MEMORANDUM

Subject: Application ID: 2013-228

Comments Submitted by: Marge Schmuckal/Zoning on 10/18/2013

This project is for 29 new dwelling units and 34 parking spaces. Two existing buildings will be demolished to make way for this project. The East Cove property is currently a legal single family. 79 Walnut Street is a legal four family. The front of this large property is along Walnut Street. The minimum street requirement of 70' is being met. The initial review indicates that the minimum setback are being met. However, I would like clarification concerning the front setback for unit #1. Is the averaging method being used? Or is the applicant depending upon another part of the Ordinance for the front setback along Walnut Street to be less than 10'. I would also like a better zoning analysis done for the newly configured lot of 128 North Street. The rear setback may be nonconforming by the rear bump out. A bit more information on that lot would be required (remaining lot size - show old lot lines compared to the new etc.).

SHEET TITLE:  
EAST ELEVATION

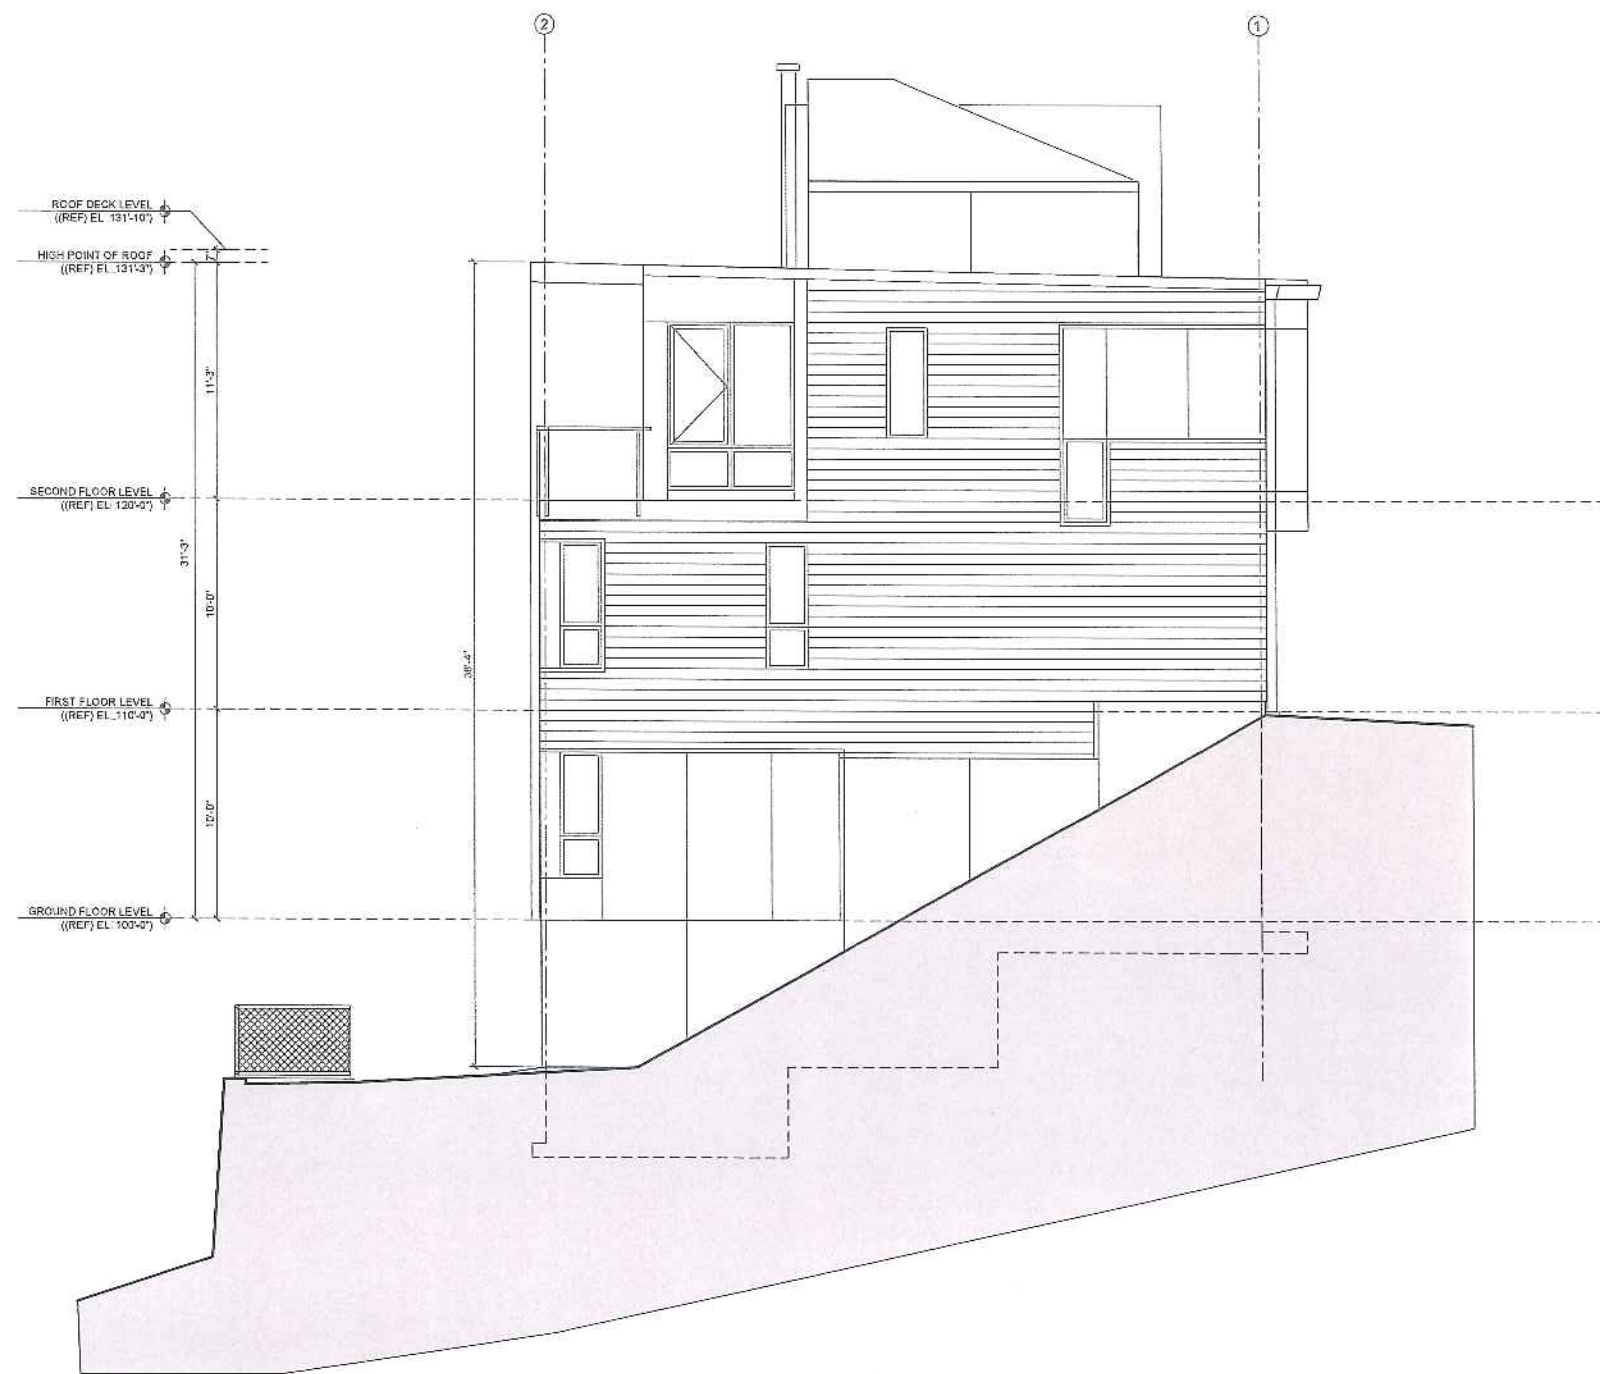
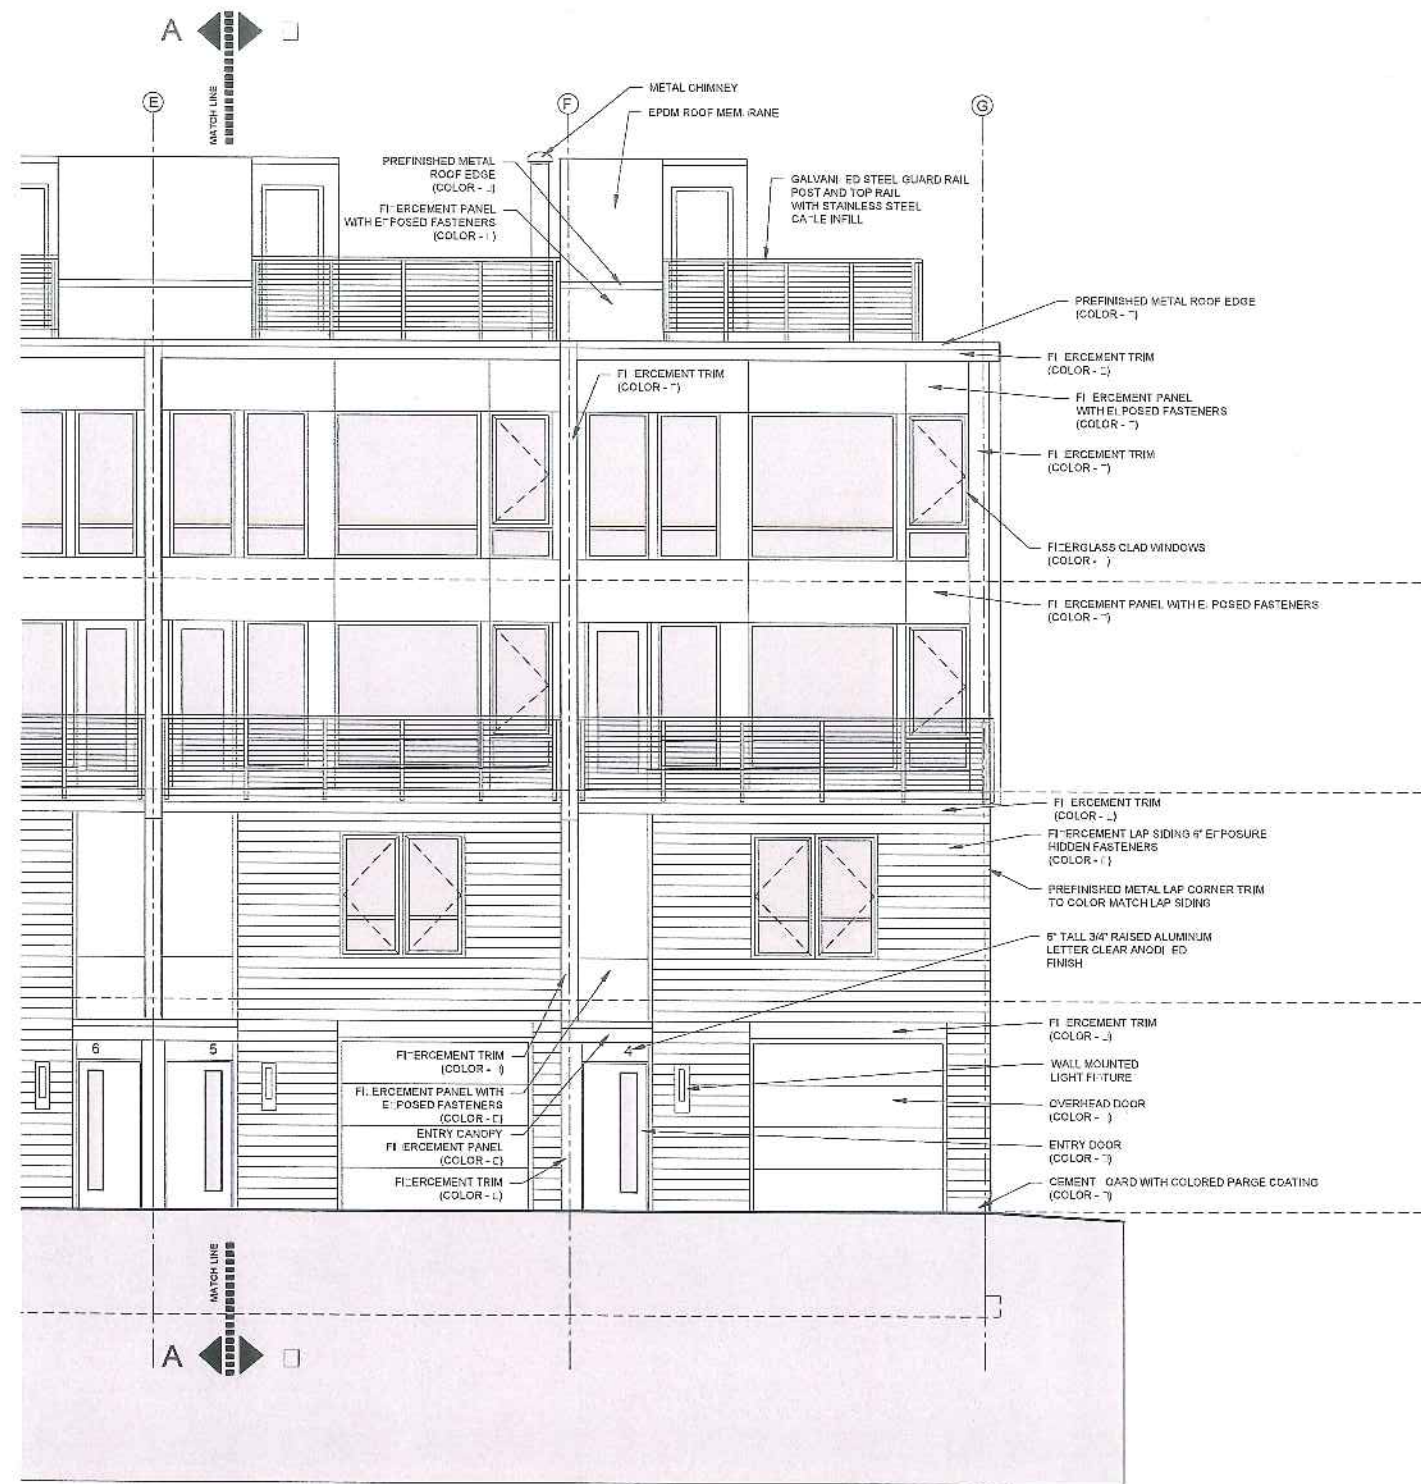
The height requirement appears to be met. However, the narrative mentioned average grades. I did not see the methodology for the average grades. The average grade was not indicated on the building elevations. Please explain the details a little bit more.

DRAWING NAME: **SITE LAYOUT PLAN**  
 PROJECT NAME: **MUNJOY HEIGHTS**  
 CLIENT: **REDFERN PROPERTIES, LLC**  
 P.O. BOX 8816, PORTLAND, MAINE 04104

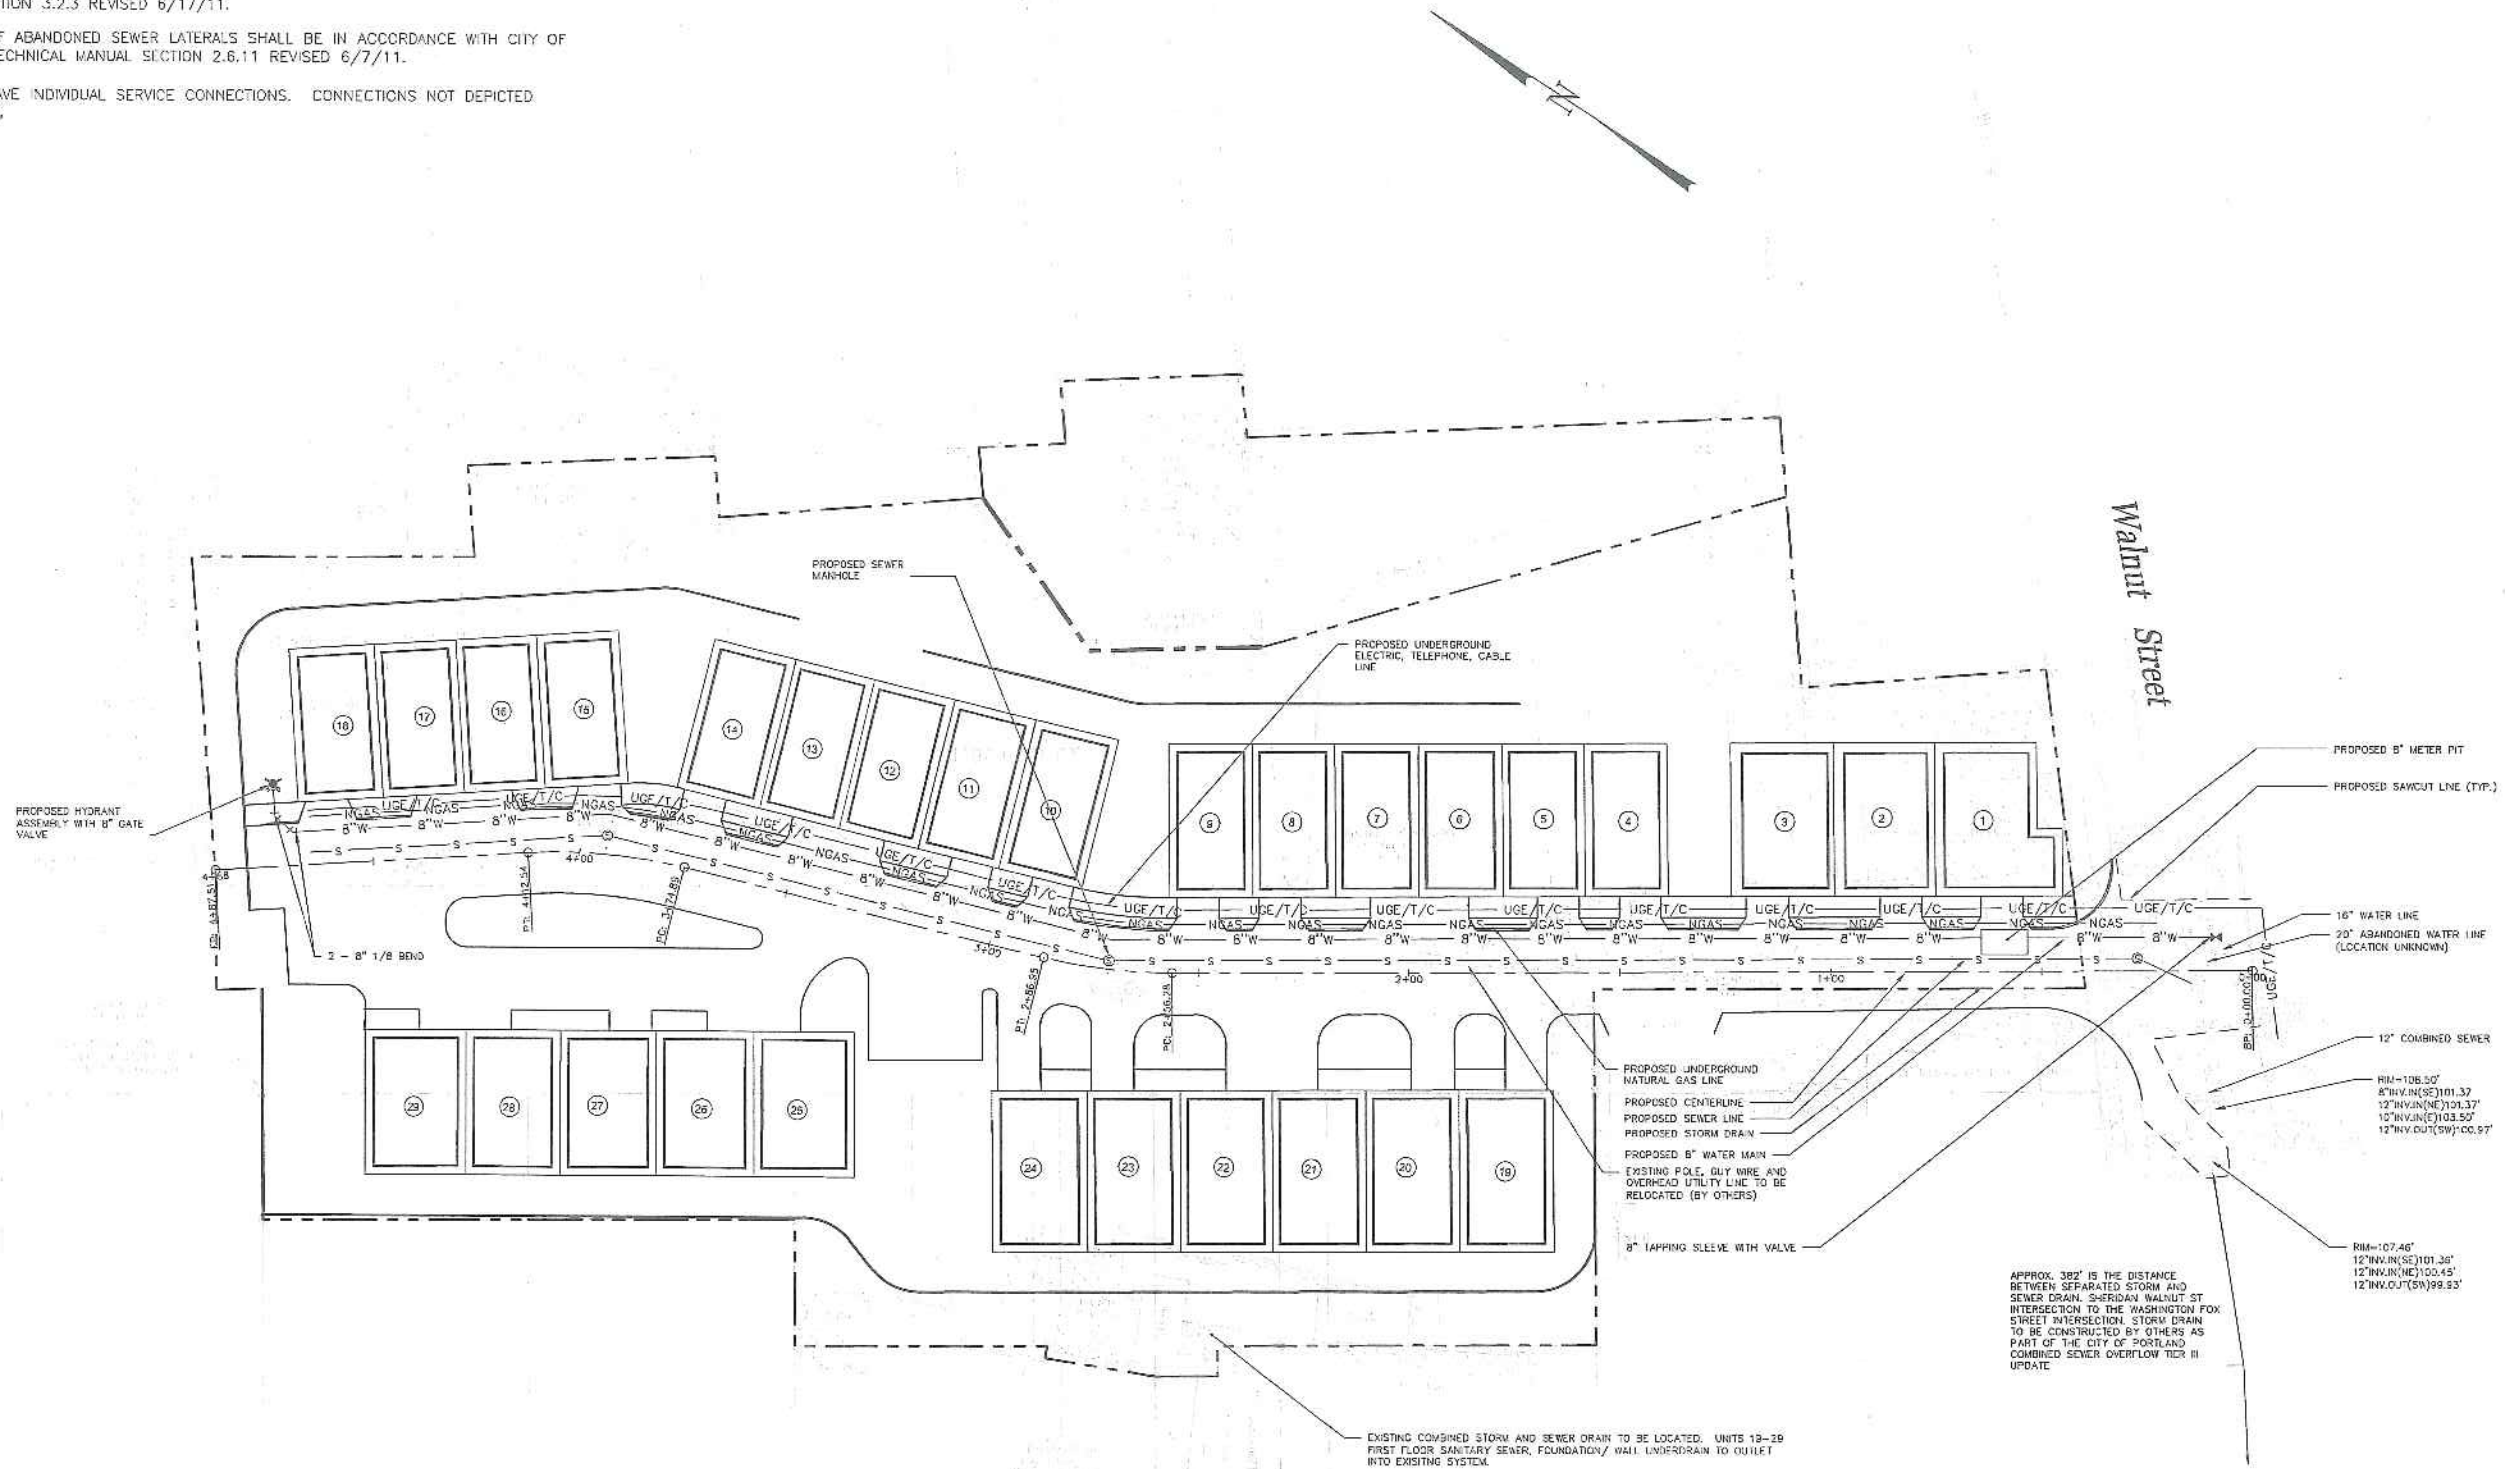
I just wanted to be sure on the plans that the "yellow" outline is the edge of the building outline for setback purposes, and not the "black" line. Please confirm.
